Land at Bilsham Road, Yapton
Planning Reference: Y/70/22/DOC

Approval of details reserved by condition imposed under ref Y/91/17/OUT relating to Condition Nos 9 - surface water drainage and 27 relating to levels.

At this stage we would recommend that these conditions are not discharged at this time until further information is provided and the comments below are addressed

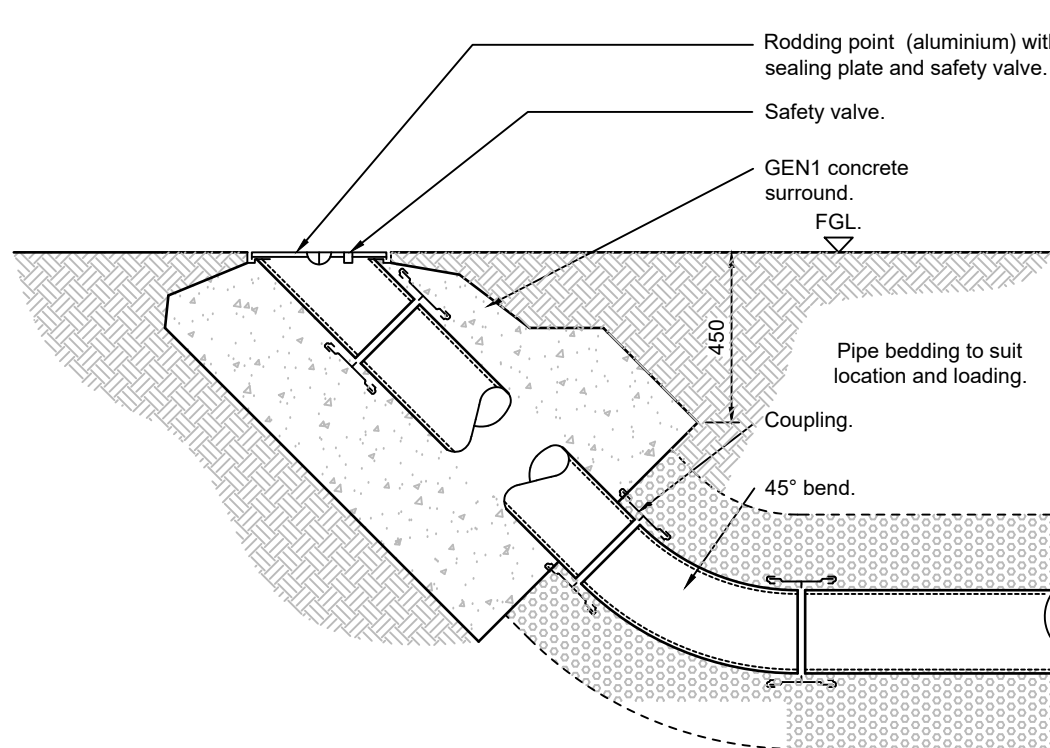
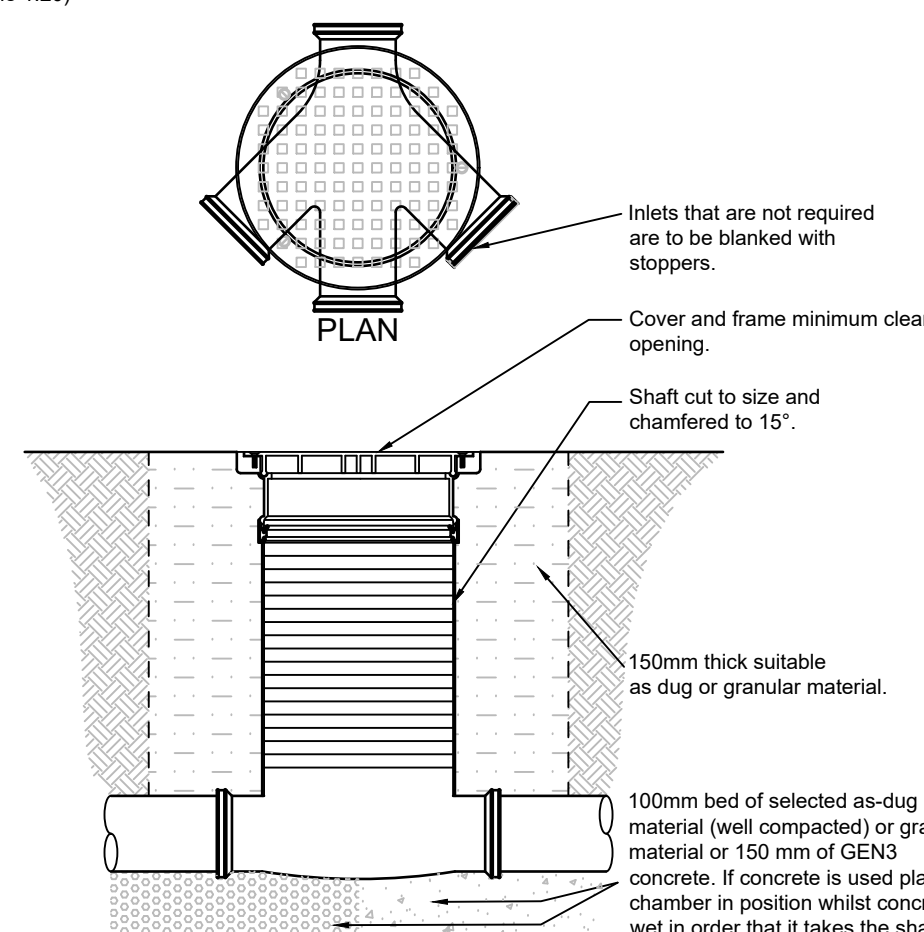
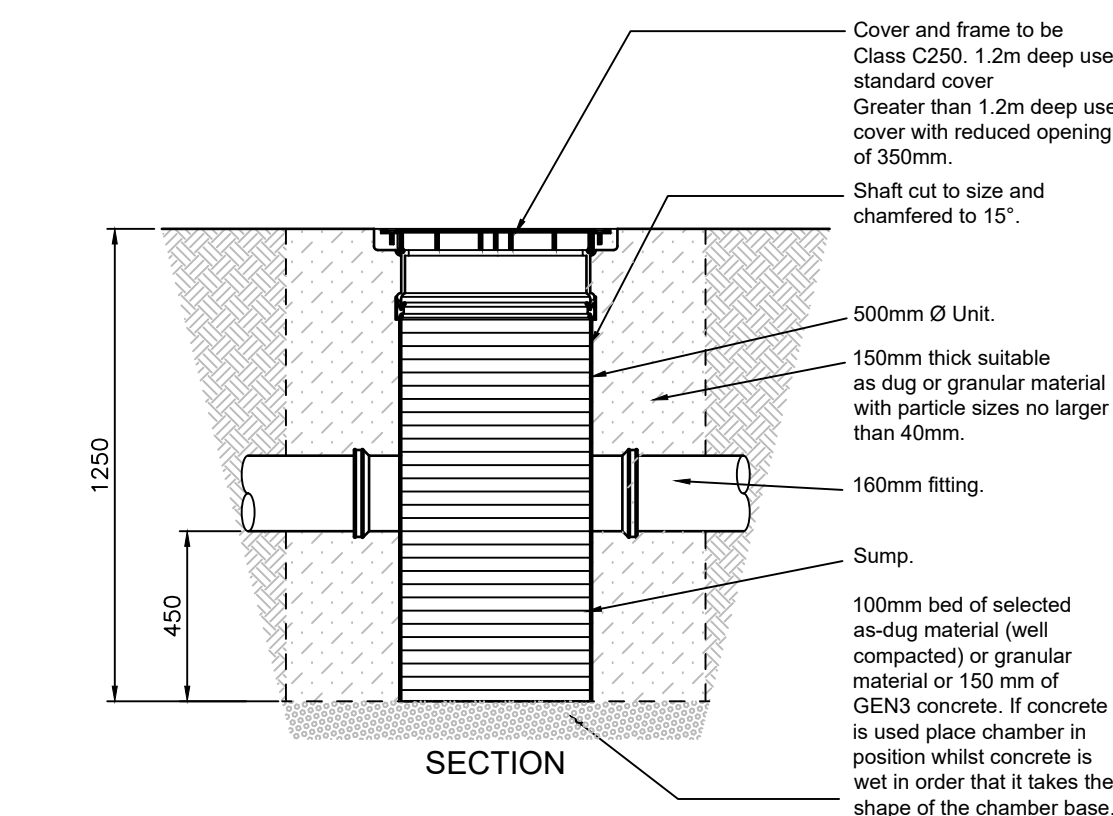
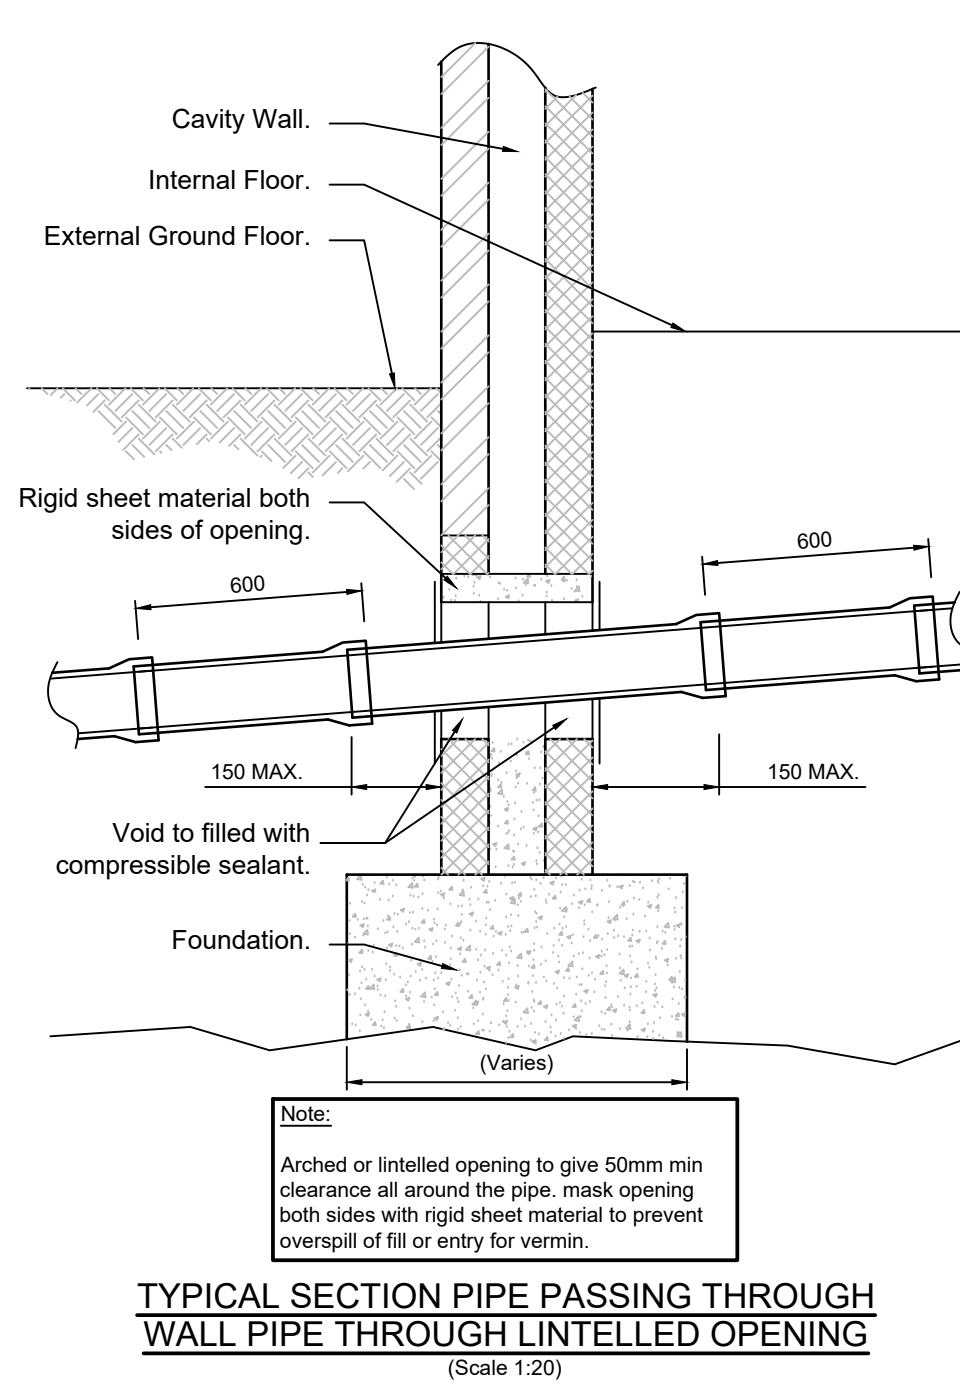
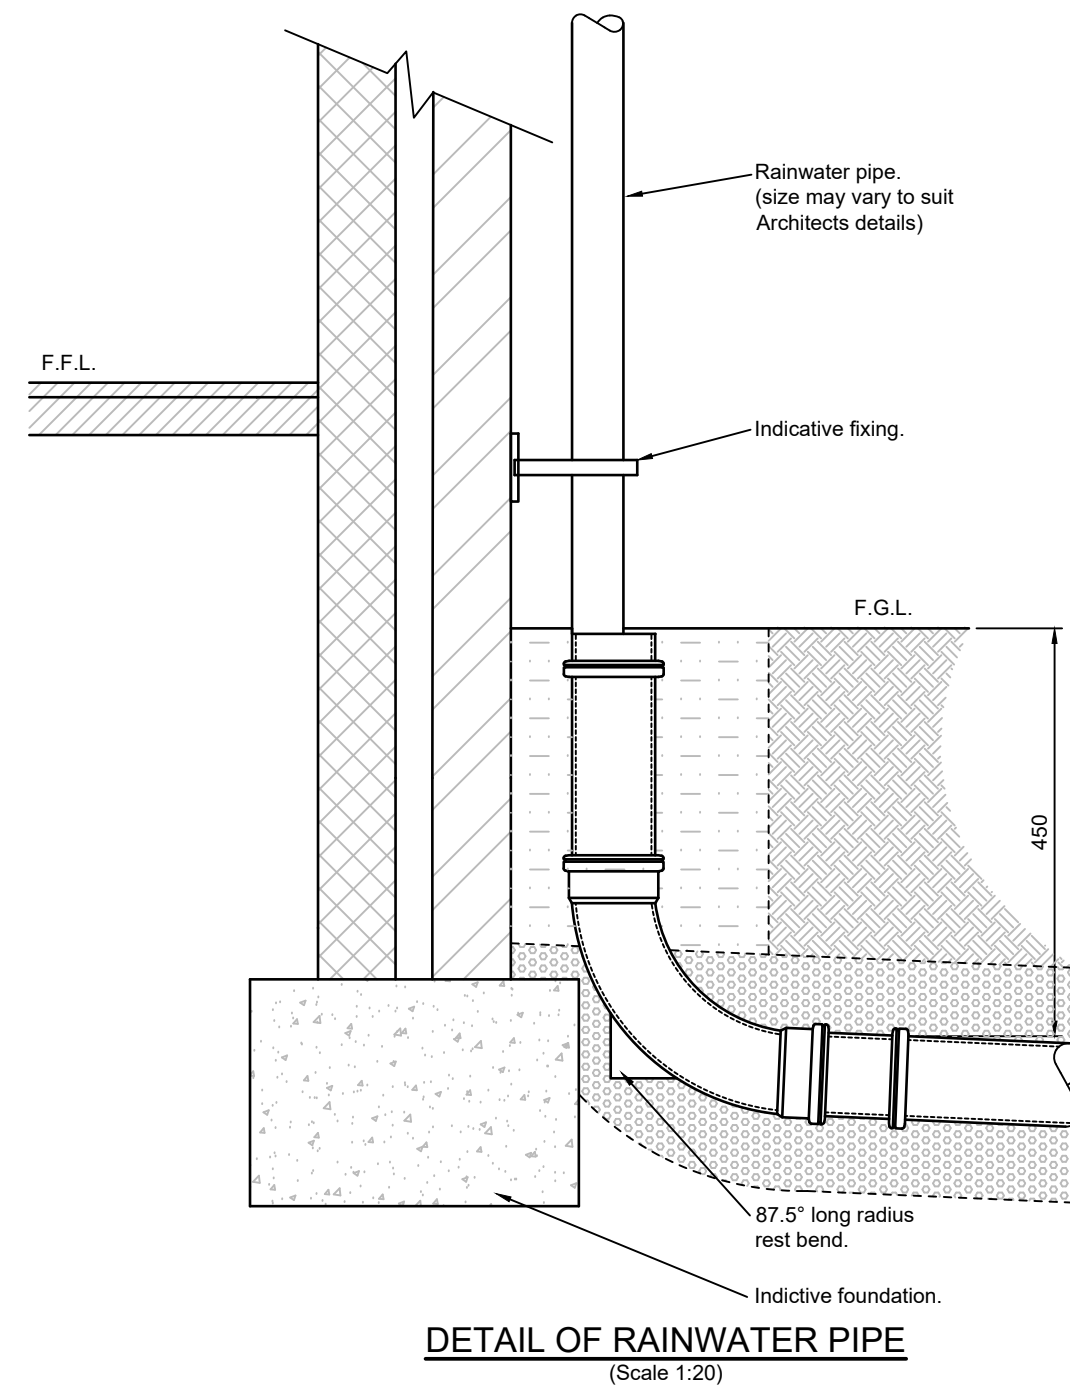
16. *Please provide a construction detail of permeable paving which clearly defines the construction, i.e. blocks, bedding, membranes, sub-base, tanking membrane. Materials and depths should be clearly defined.* The construction detail shown on drawing D1956-15.2 conflicts with that shown on D1956-15-3A. These need to be updated to ensure there is no conflicting information. In addition to this its not clear why part infiltration has not been sought in areas where the infiltration has demonstrated that this is achievable. The applicant should clarify clear reasons as to why infiltration techniques have not been used for the

permeable paving in the areas within the vicinity of the following test locations: TP05; TP04; TP01. 08/2/2023- This has now been received and we have no further comments.

Drawing No. D1956-15-3

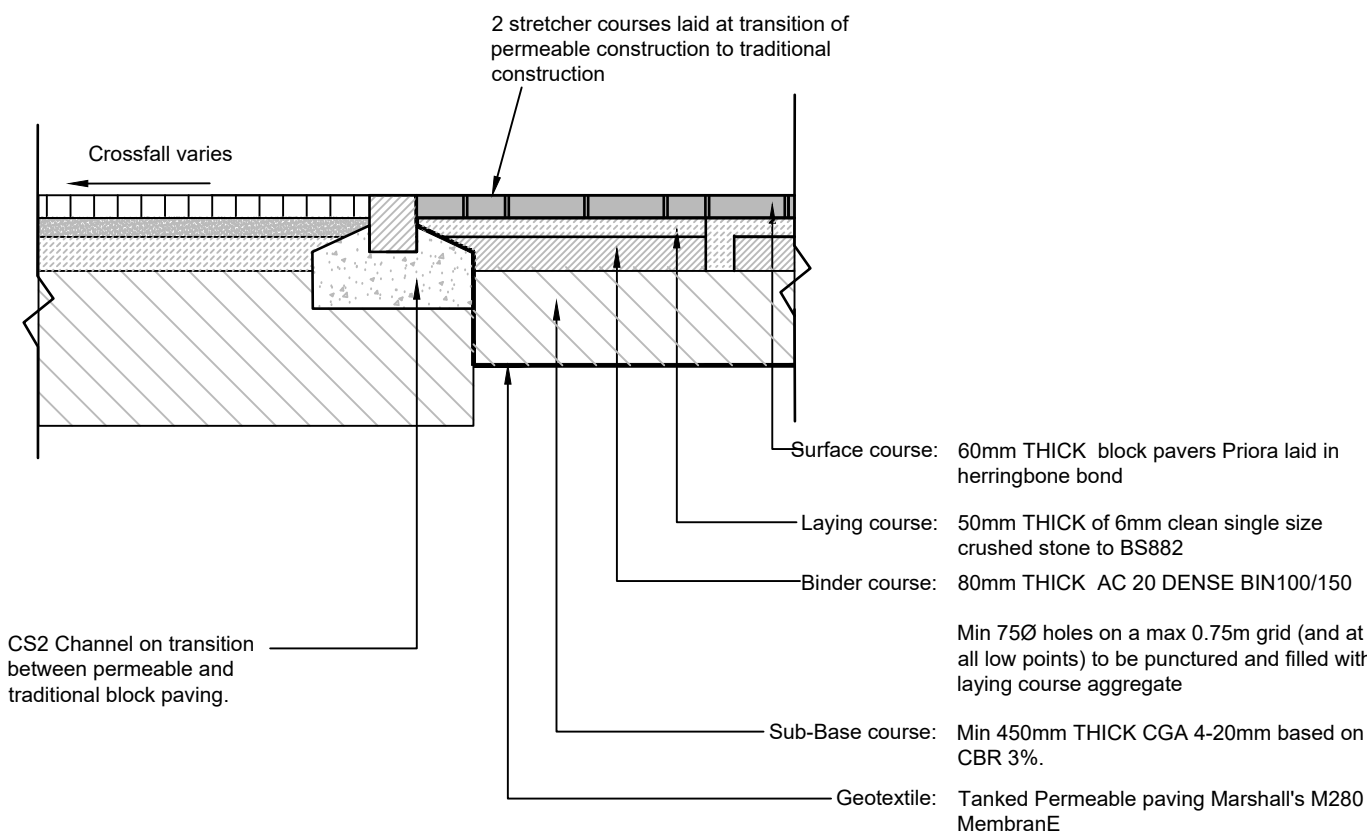
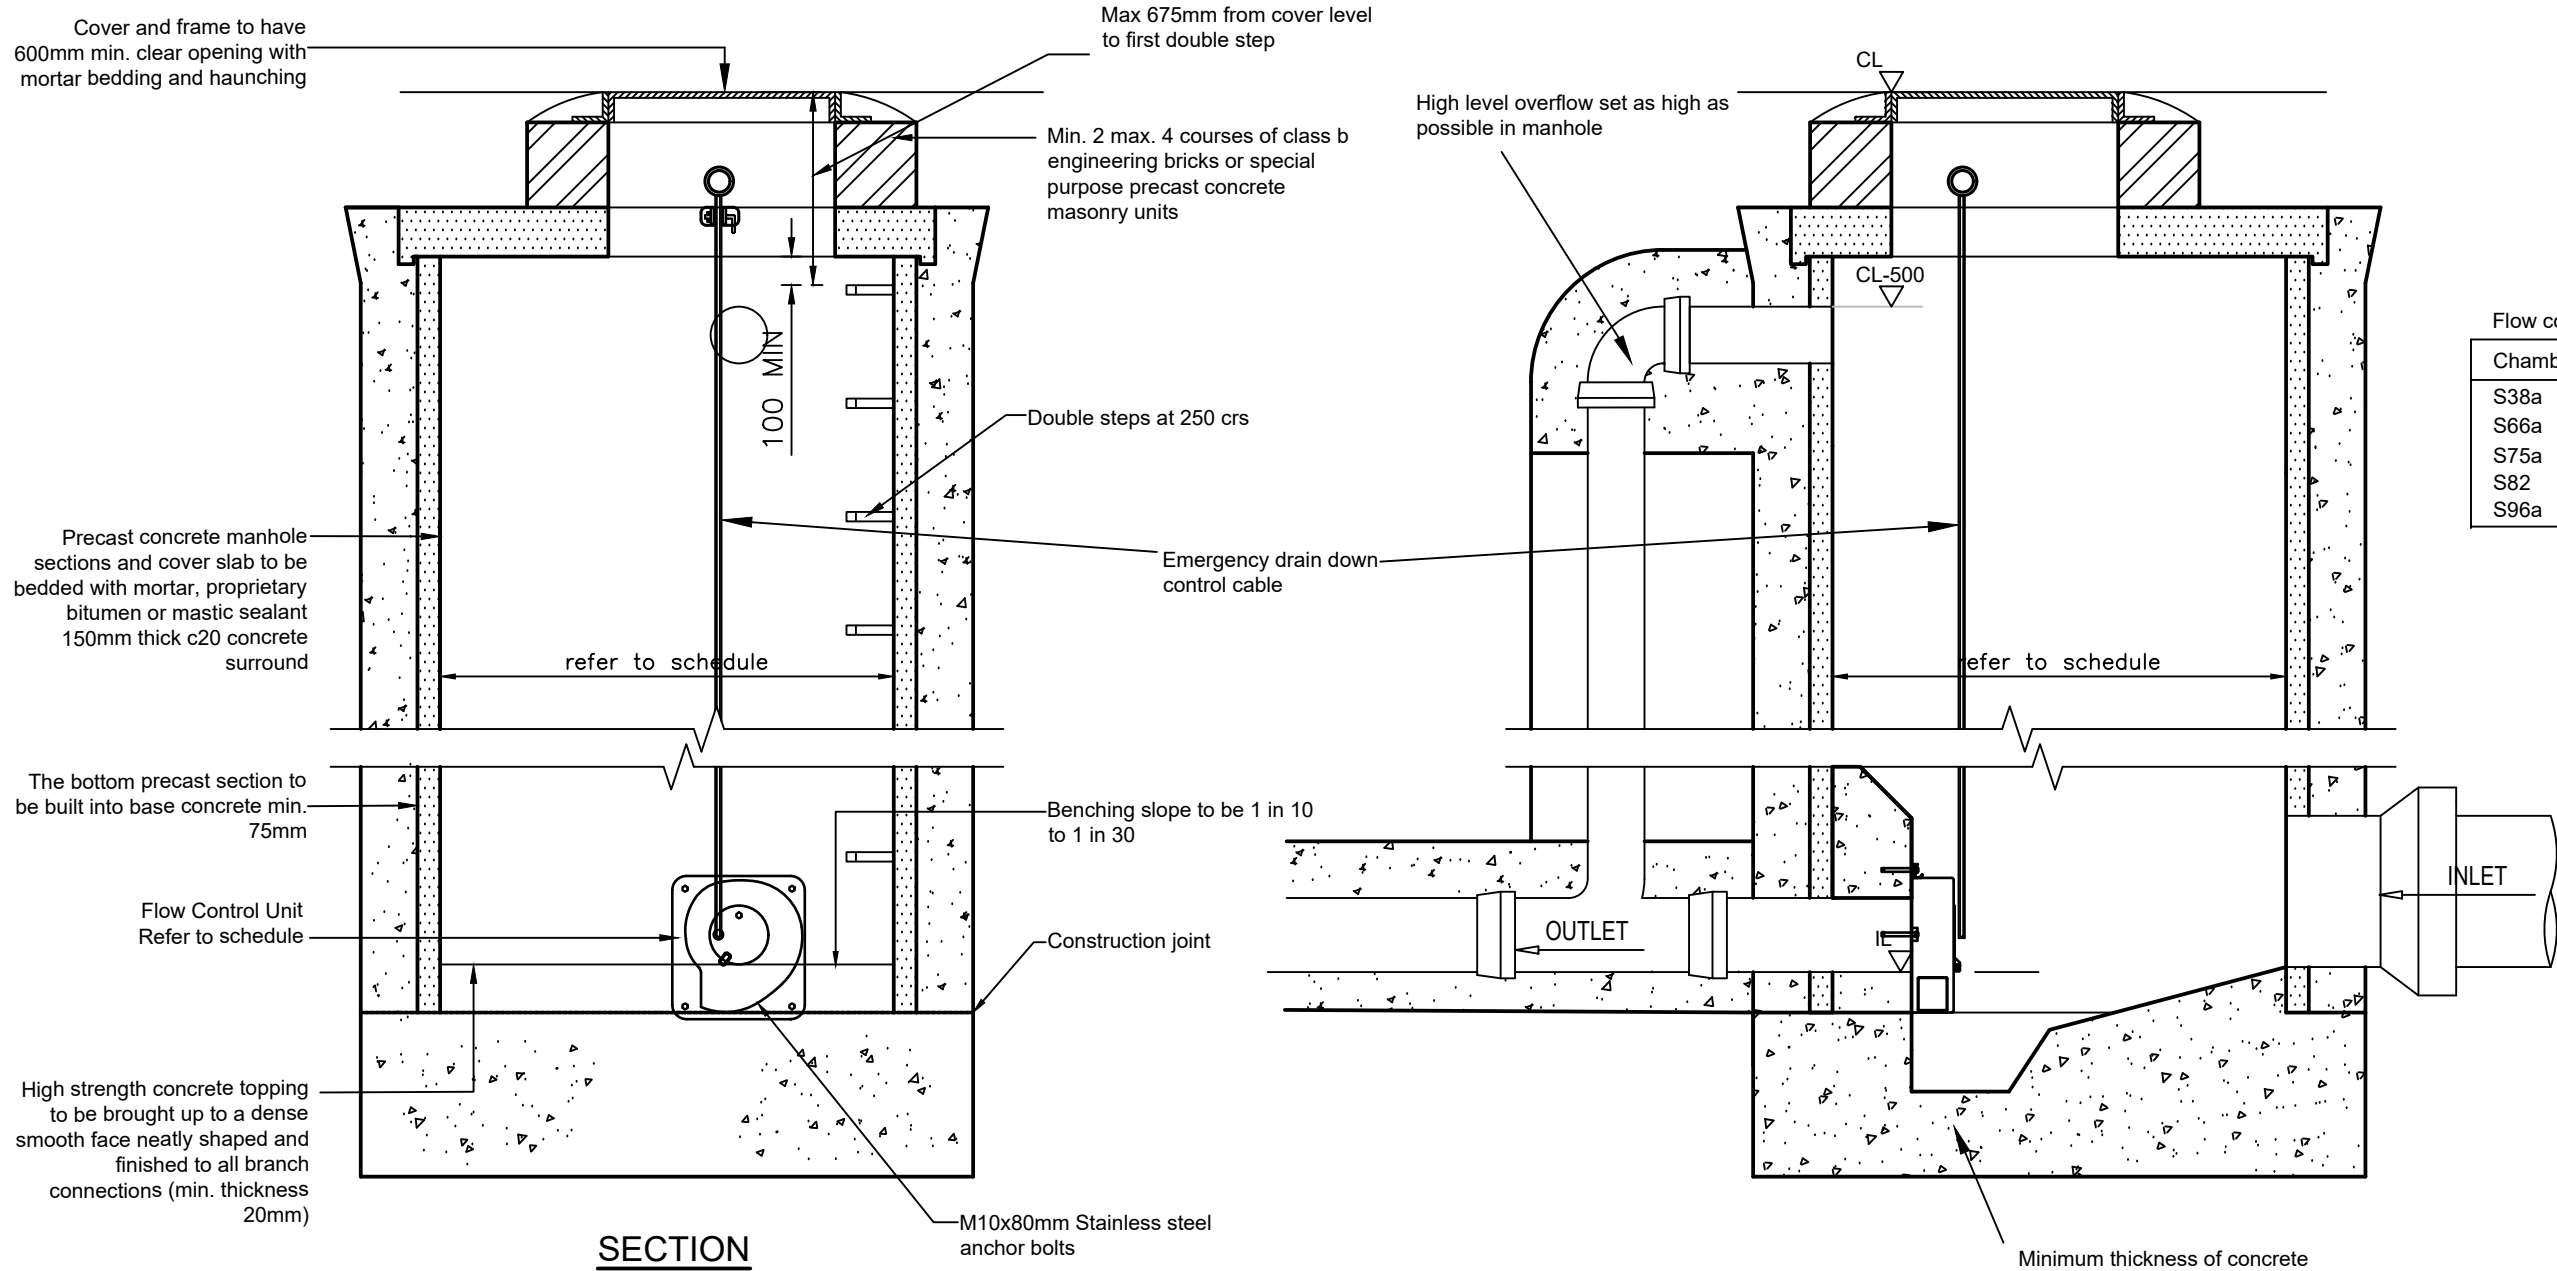
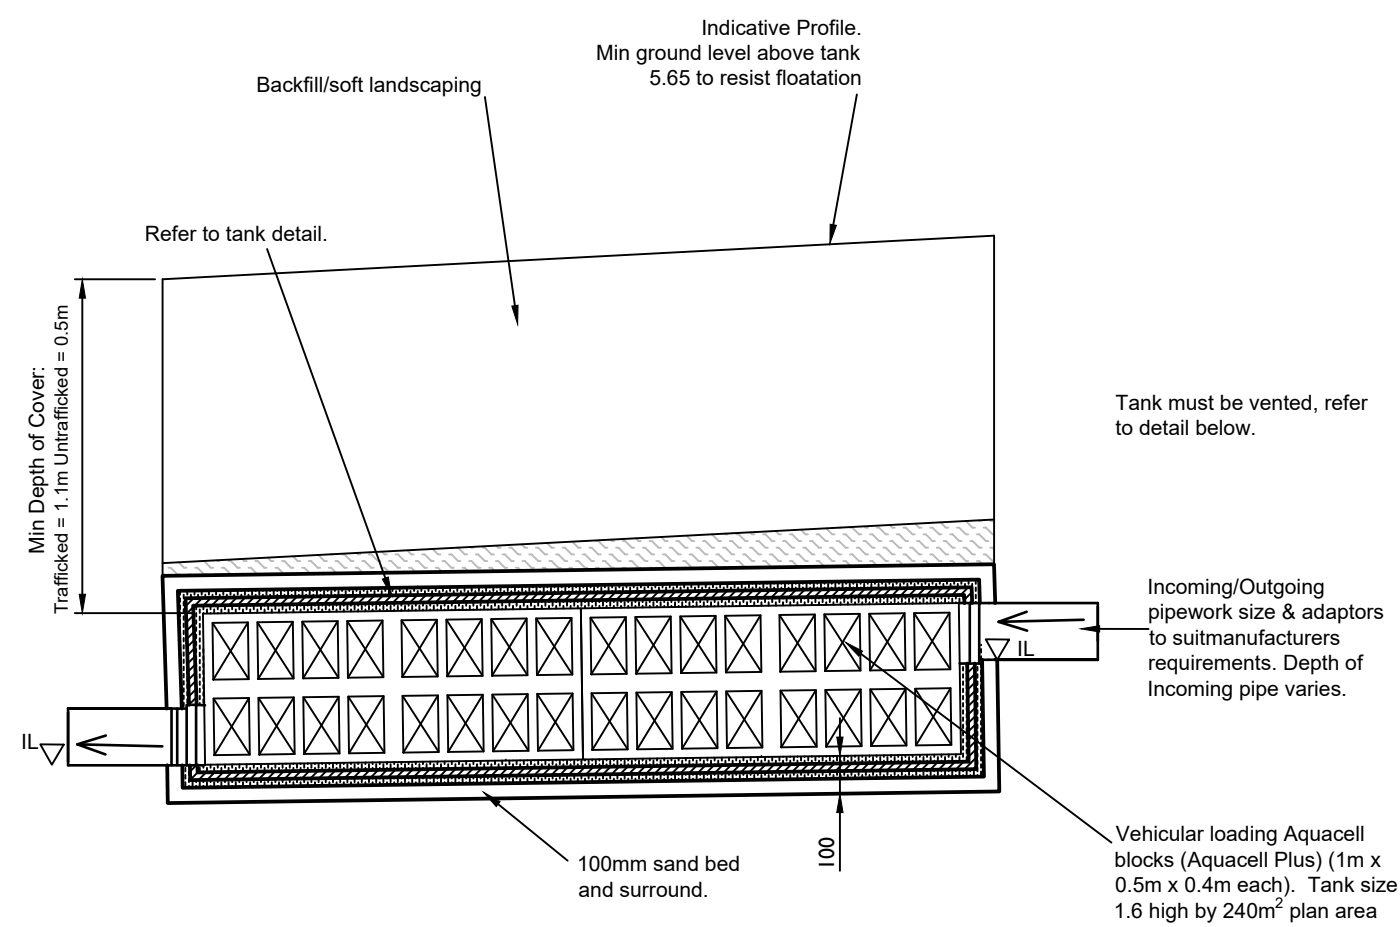
13. *There are inconsistencies between layout and details for the attenuation tank. Layout states a depth of tank of 1.5m but detail states a depth of 1.6m. Please ensure consistency. The calculations still state 1.5m . Please also resubmit the construction details for this tank as part of this discharge application 08/2/2023- This has now been received and we have no further comments.*
